**KIRKLEES METROPOLITAN COUNCIL  
INVESTMENT & REGENERATION SERVICE**

**DELEGATED DECISION TO DETERMINE PLANNING APPLICATIONS**

Reference No:	<b>2023/62/92549/W</b>
Site Address:	25, Lynndale Avenue, Birkby, Huddersfield, HD2 2XP
Description:	Change of use and alterations to convert one dwelling/HMO to 2no. self-contained, single bedroom flats (within a Conservation Area)
Recommending Officer:	Tom Hunt

Drawing Title:
Proposed Layout

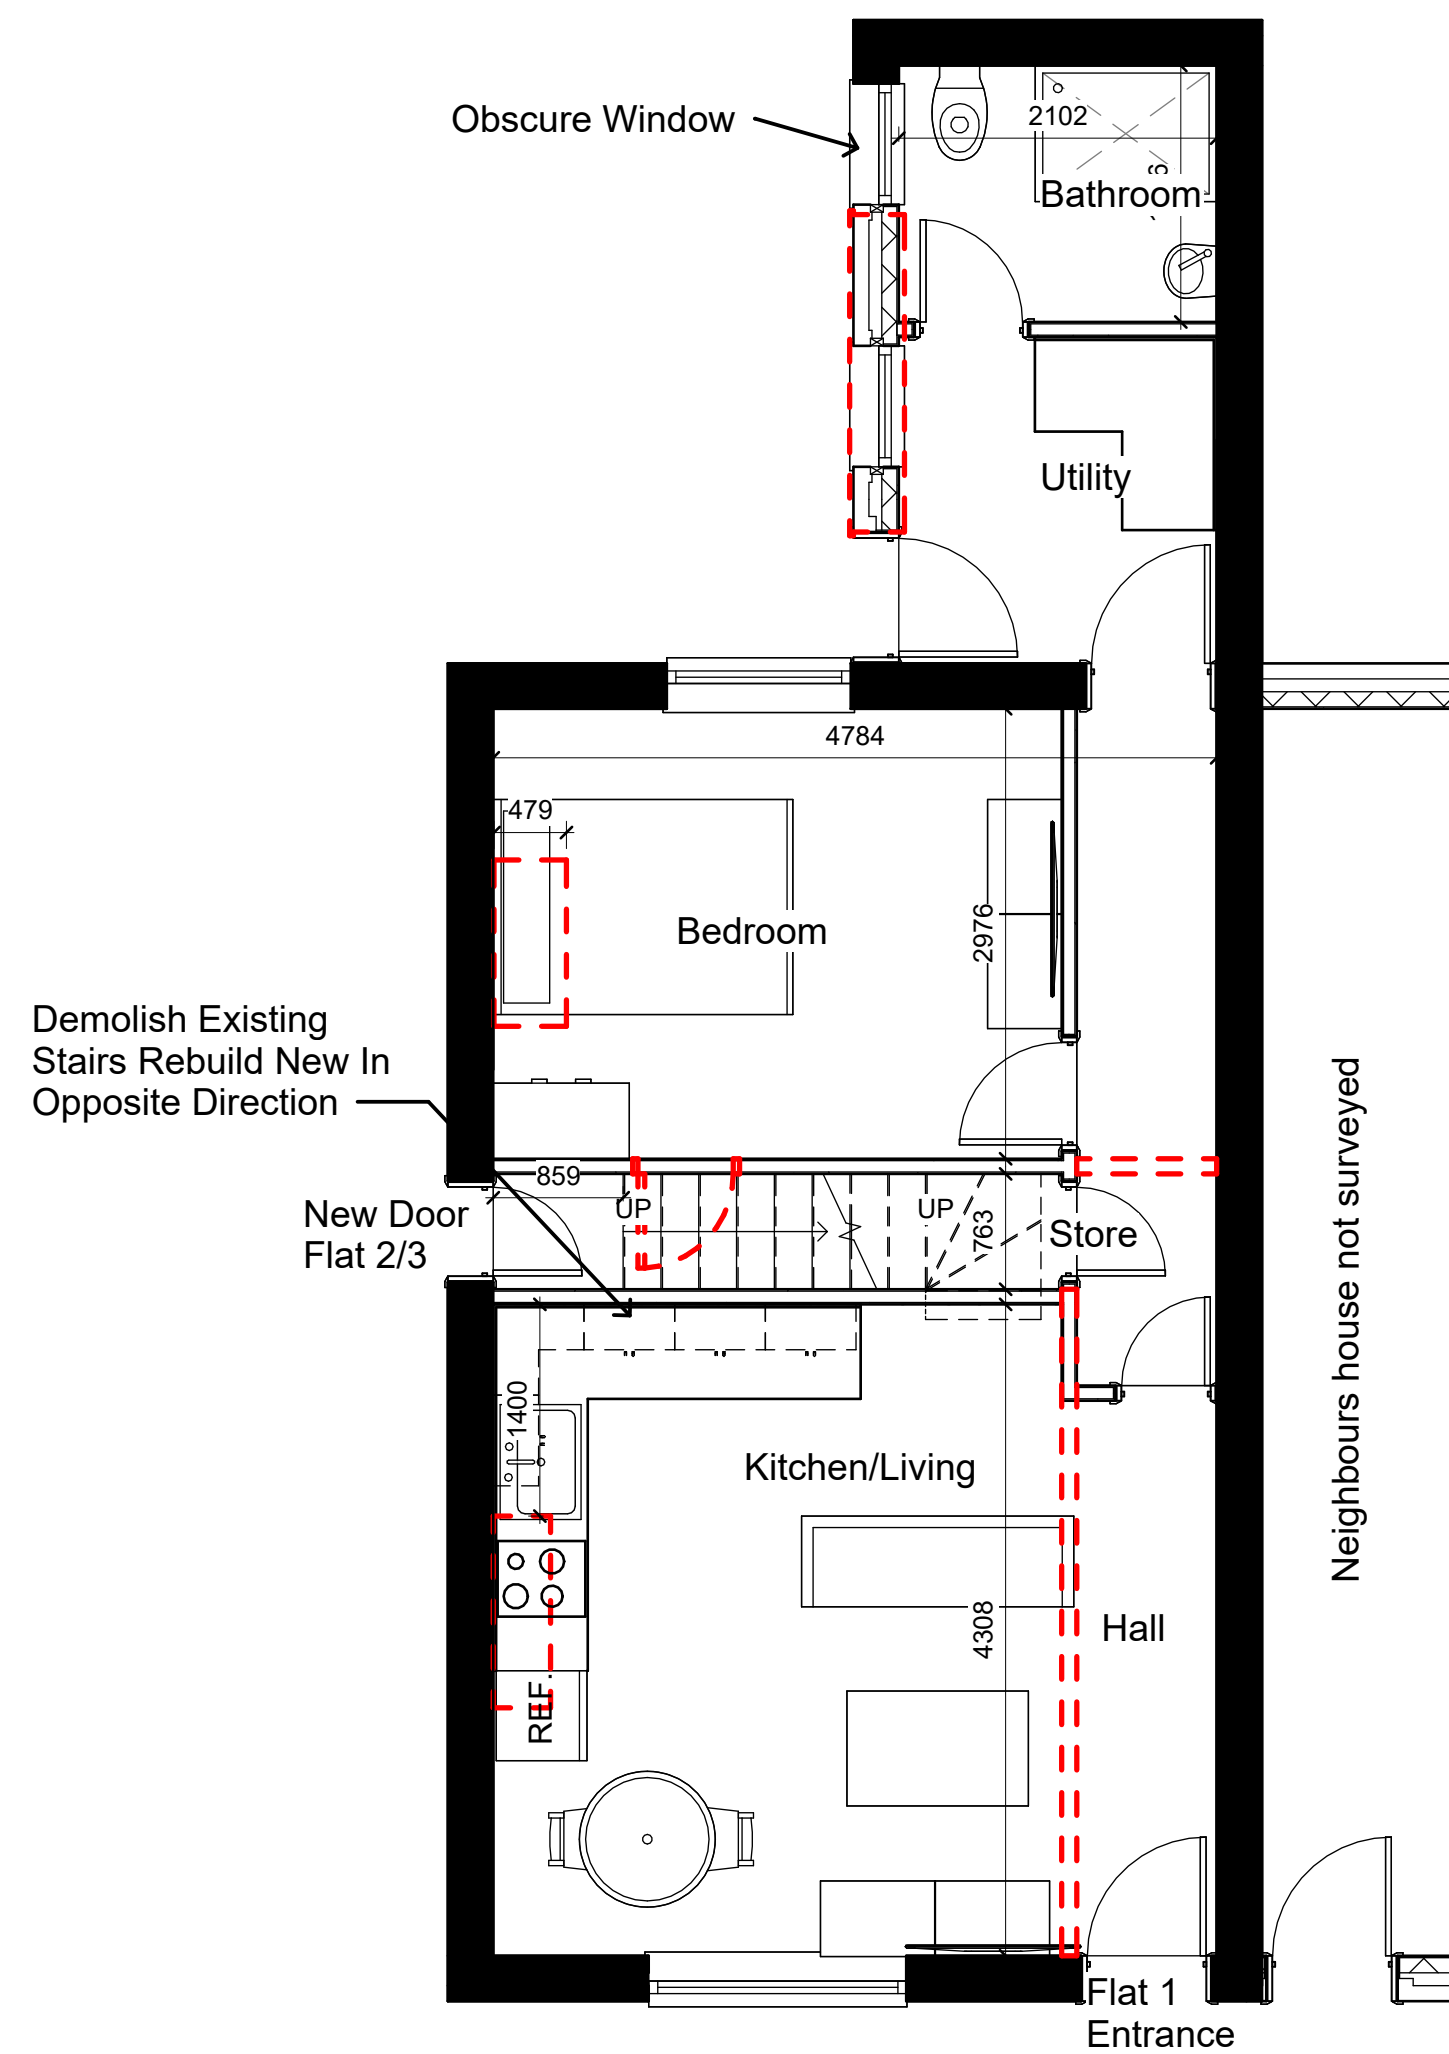
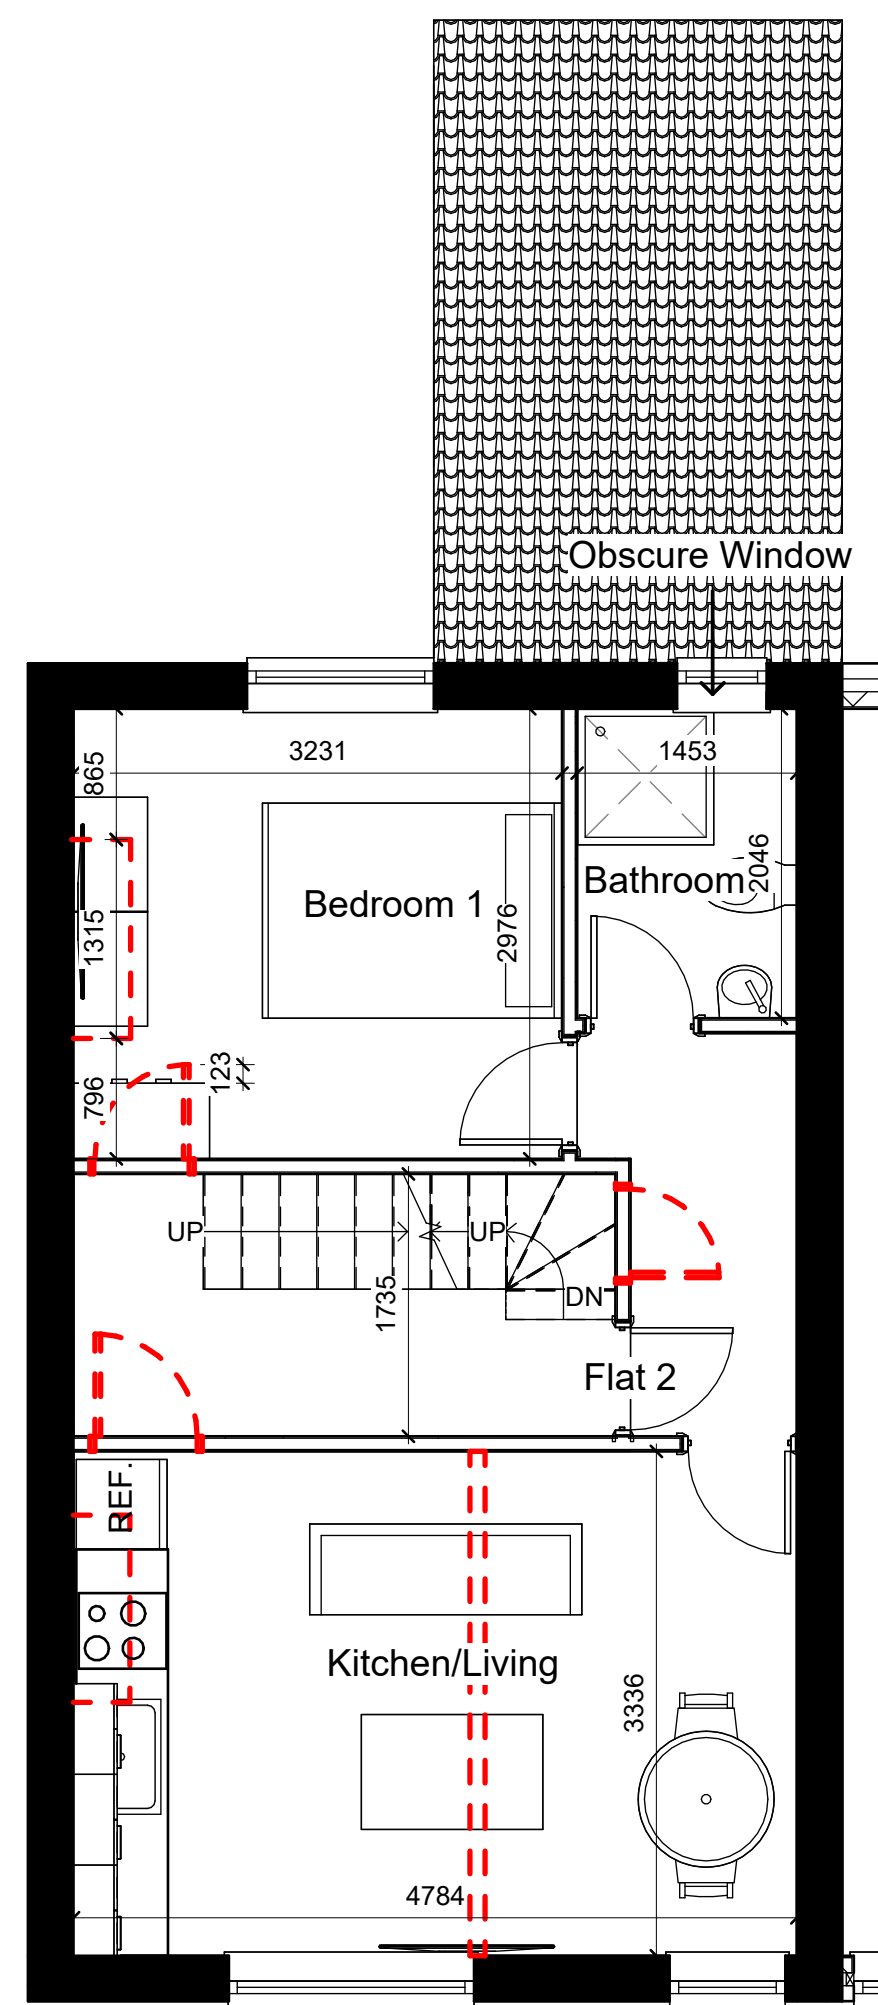
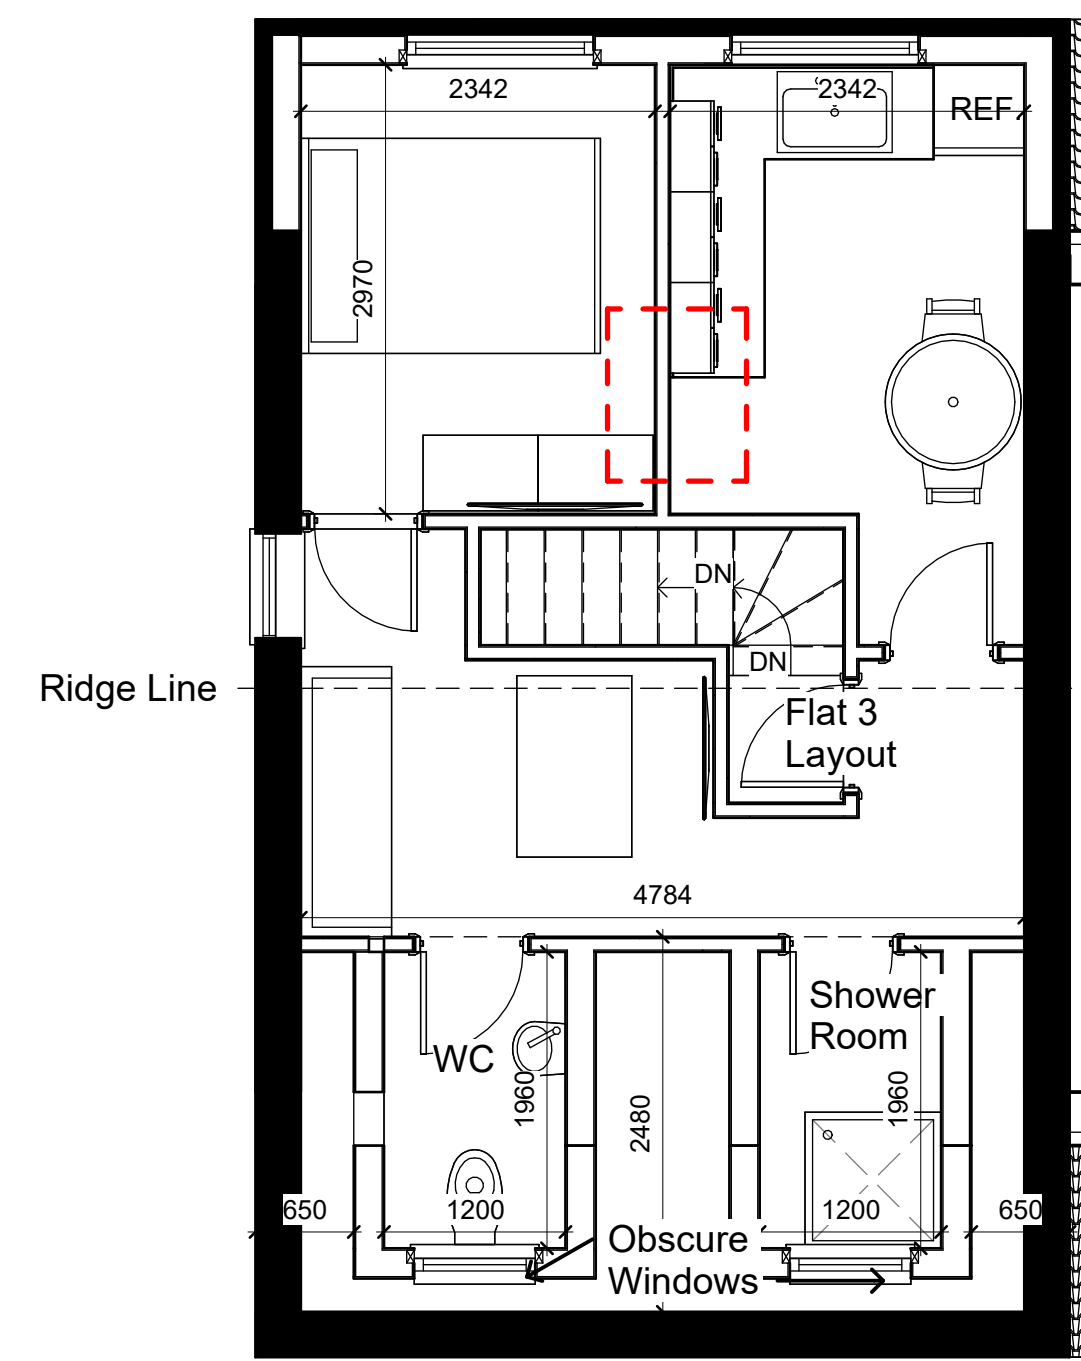
It is proposed to have two existing side/northeast elevation windows made larger and an existing side elevation window converted to a door.

It is proposed to have a change of use from dwellinghouse to two self-contained double bedroom flats with access from the front for flat 1 and from the side for flat 2.

Flat 1 would have a gross internal floorspace of approx. 47sqm. The flat would comprise of a single person bedroom (~11.2sqm), shower-room, and open plan kitchen/lounge.

Flat 2 would have a gross internal floorspace of approx. 39sqm to 1<sup>st</sup> storey and 14.7sqm to the attic. The flat would comprise of a single person bedroom (~9.3sqm), shower-room, open plan kitchen/lounge and upstairs area.

**Officer Note:** Plans indicate lower internal floor space for each flat as they exclude the staircase; the Officer has measured the Gross Internal Floor space in accordance with the Nationally Described Space Standards (NDSS).

Bin storage is shown on the submitted plans adjacent to flat 1 and to the doorway of flat 2. This could be considered acceptable with no side elevation
